Planning Services Sign Permit Review Form

Date of Submittal	Application Number	Applicant	Landowner
7/21/2025	SIGN2507-0001	Lian Farruggio	KB Home Raleigh Durham Inc.

Contact Person	Lian Farruggio	Contact Number	919-884-6279
Sign Location	Olive Branch Road	PIN Number	0642-74-2709.000

Reviewed By:	Date of Review	Review Results
Randy Baker	7/28/2025	<input type="checkbox"/> Approved <input checked="" type="checkbox"/> Denied

Project	Sheet
Date 7.21.2025	L-2
Scale 1" = 10'-0"

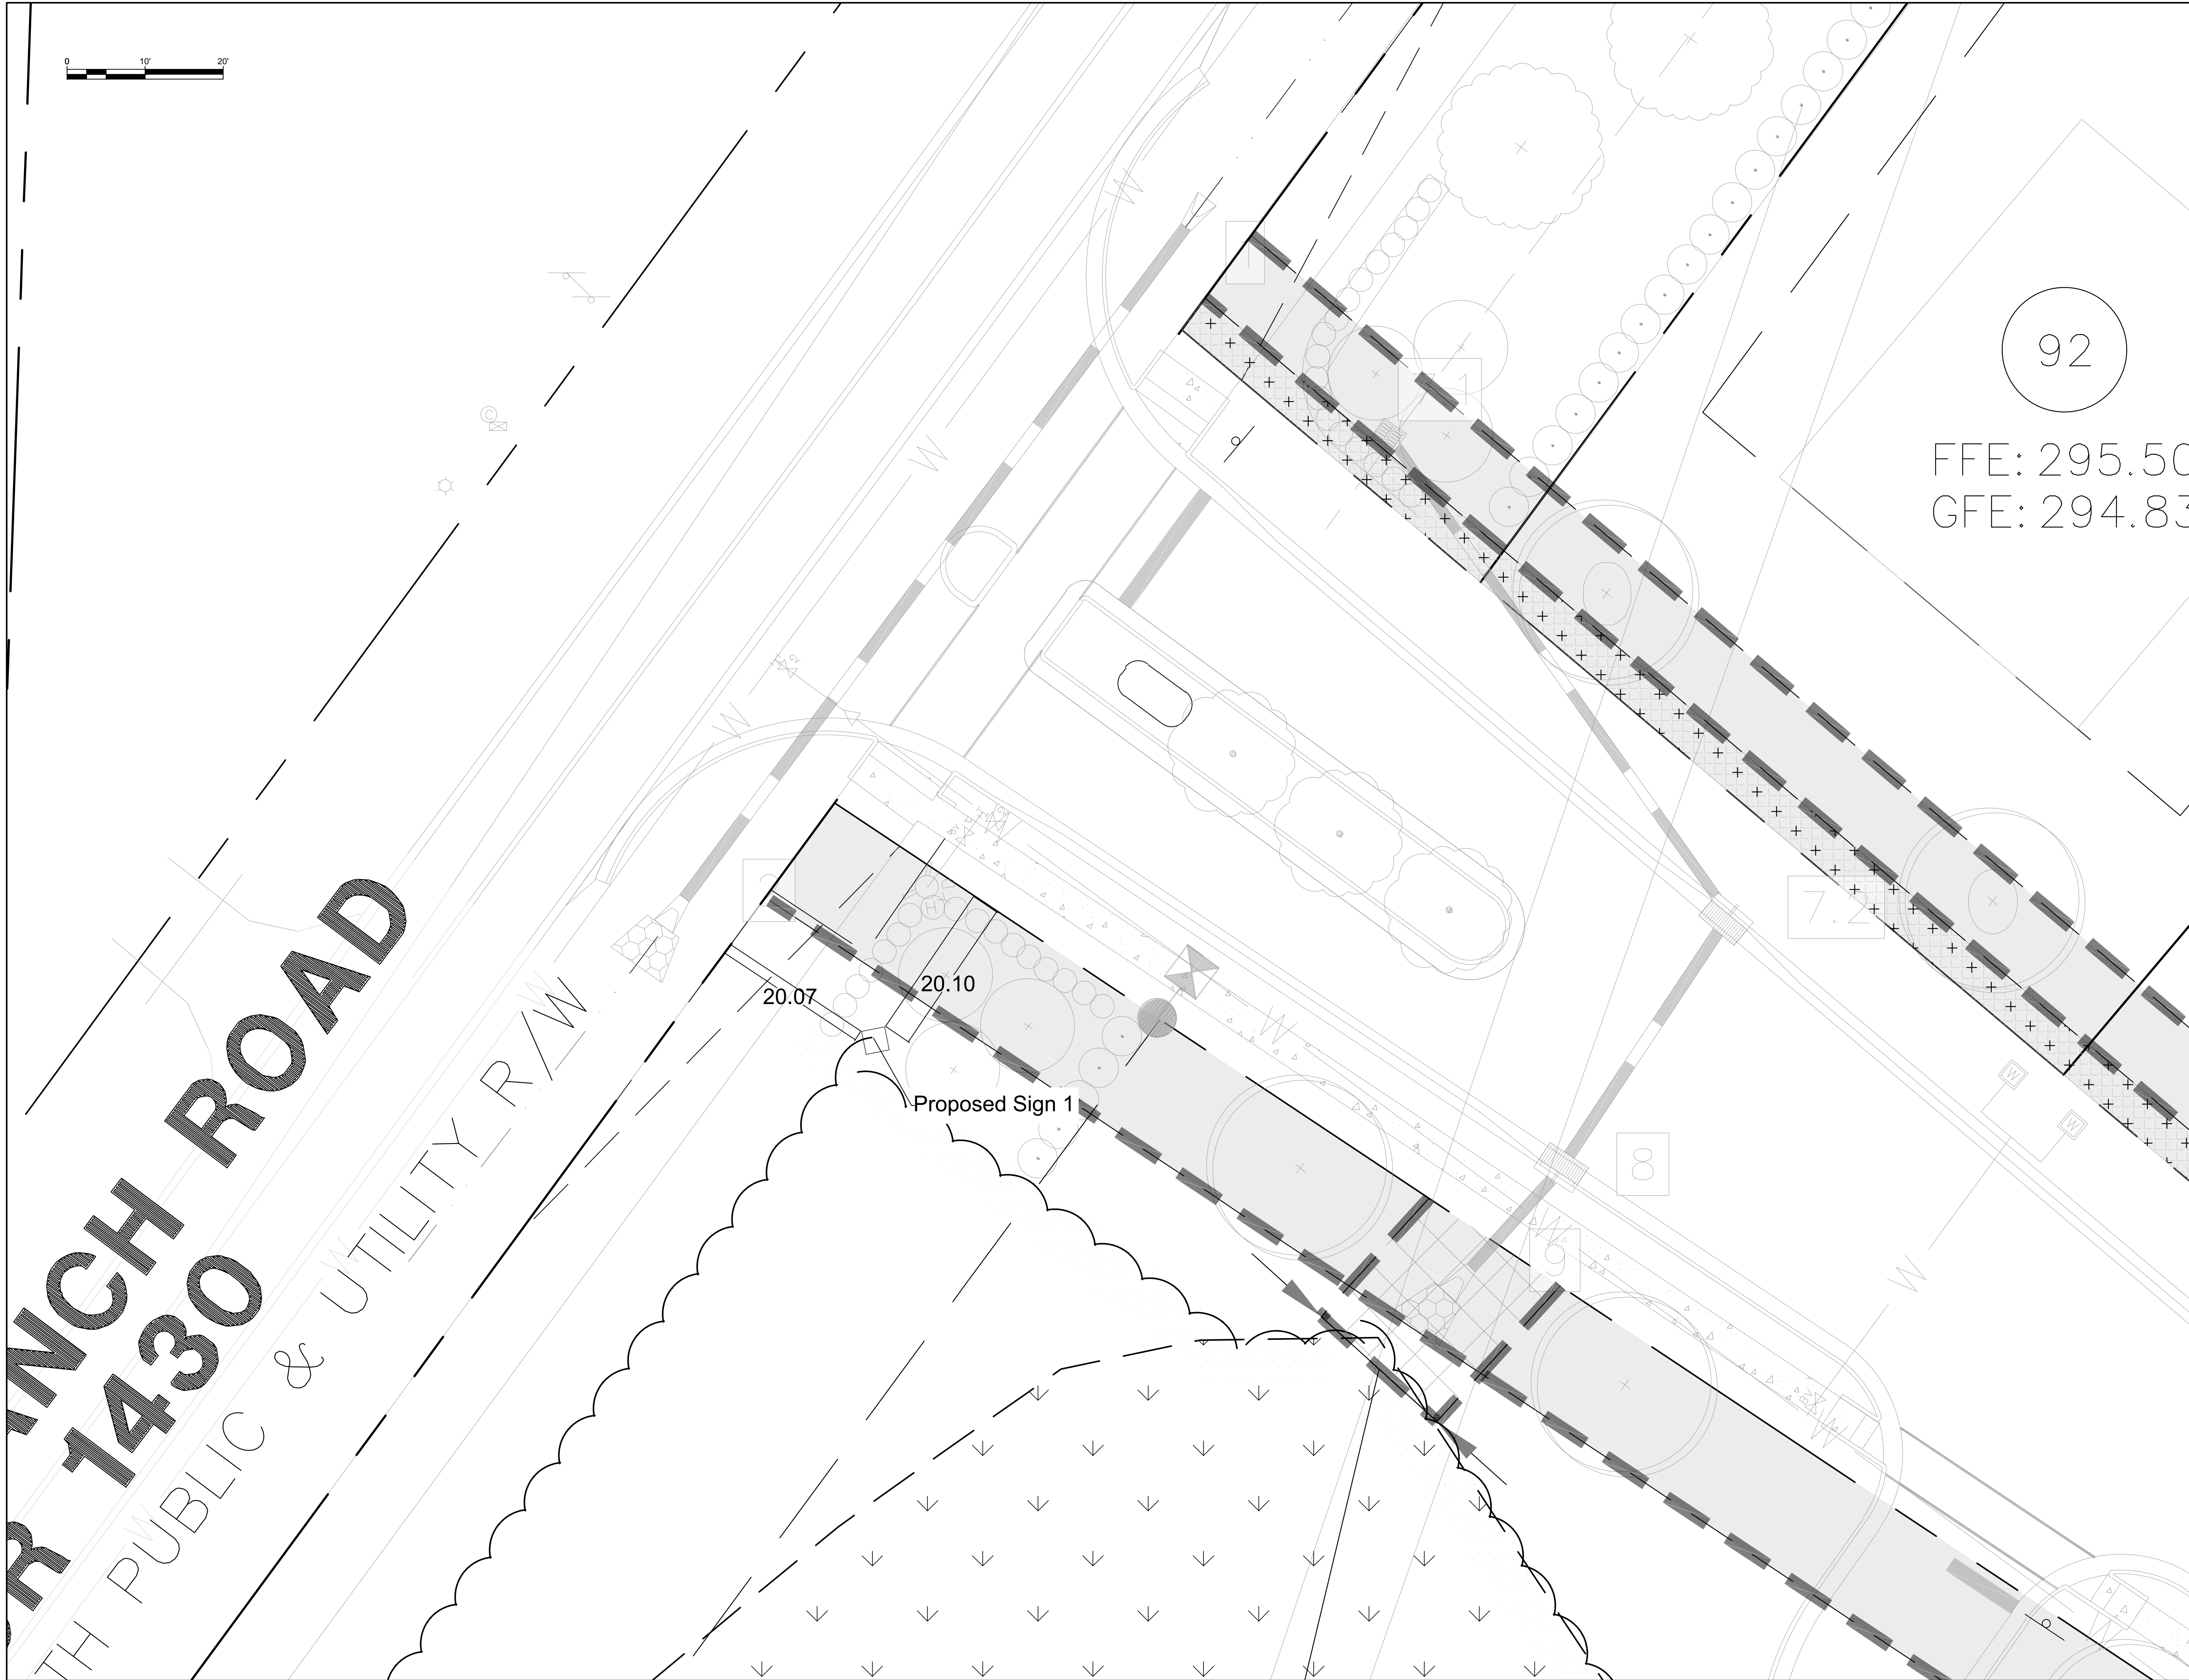
Comments	In cases where signs are placed at intersections, the minimum setback shall be 20 feet as measured from each right-of-way line or property line in both directions.
----------	---------------------------------------------------------------------------------------------------------------------------------------------------------------------
